Slocum Custom Builders
Rt. 115
North Yarmouth, ME

June 11, 2013
Job No. 2013-114
Pg. 1 of 1

Subject: Framing inspection at 38 Bismark St., Portland, ME.

PROPOSED FLOOR PLANS  
 JUNIEWICZ REMODEL  
 PORTLAND, ME

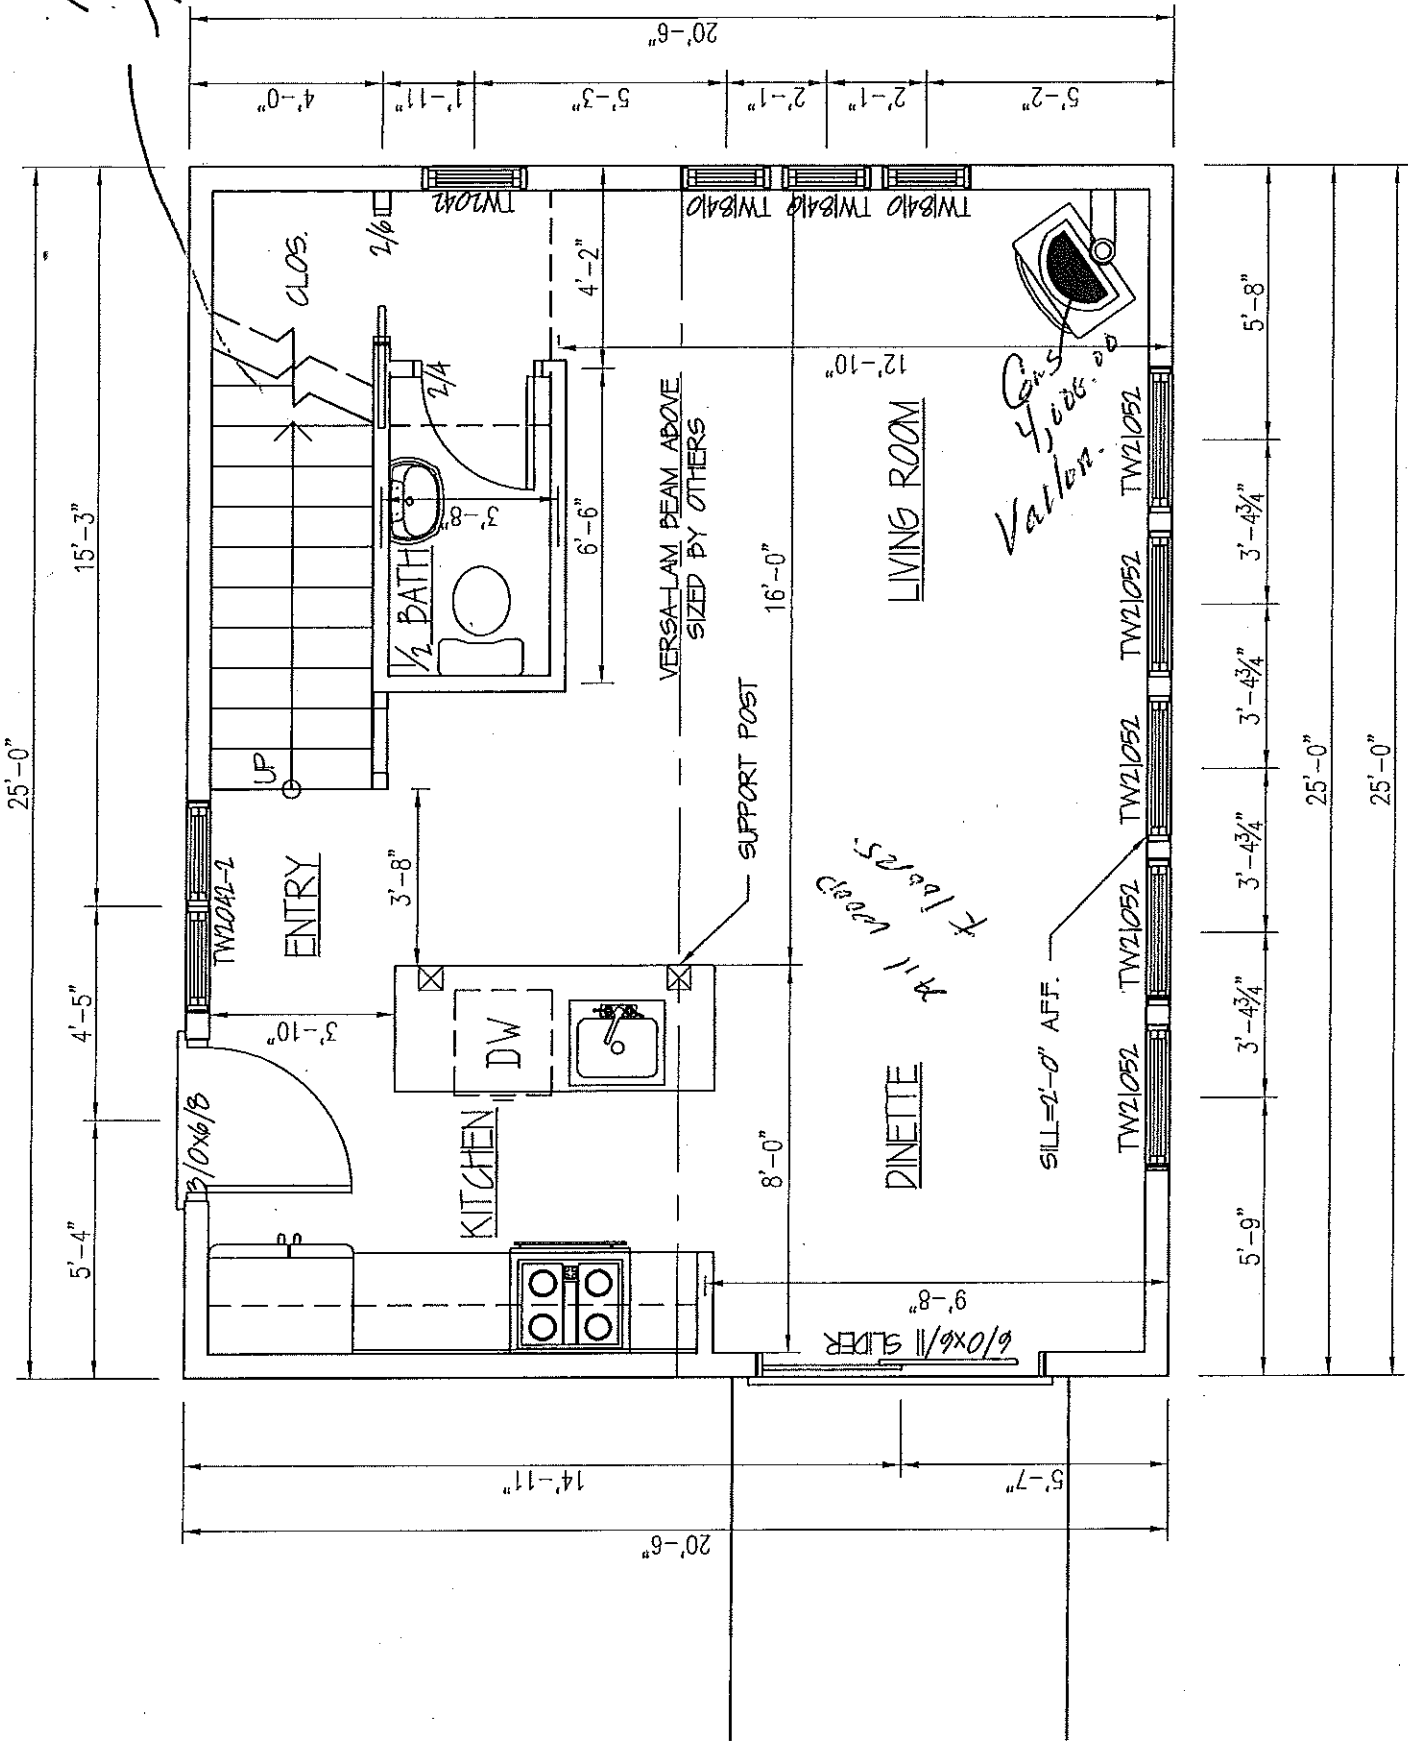
I have reviewed the size of the installed LVL Headers. The 16ft. LVL header (2-1.75"x11.875"lvls) over the outside windows will receive additional studs installed between each window, reducing the clear span too less than 4ft. With this added support, this header is adequate to support IBC 2009 mandated live loads for residential construction for both strength and deflection.

The (3) 1.75"x.9.25" LVL girder supporting the second floor joists near mid-span, and clear spanning 13'-8" is also adequate to support IBC 2009 mandated live loads for residential construction for both strength and deflection.
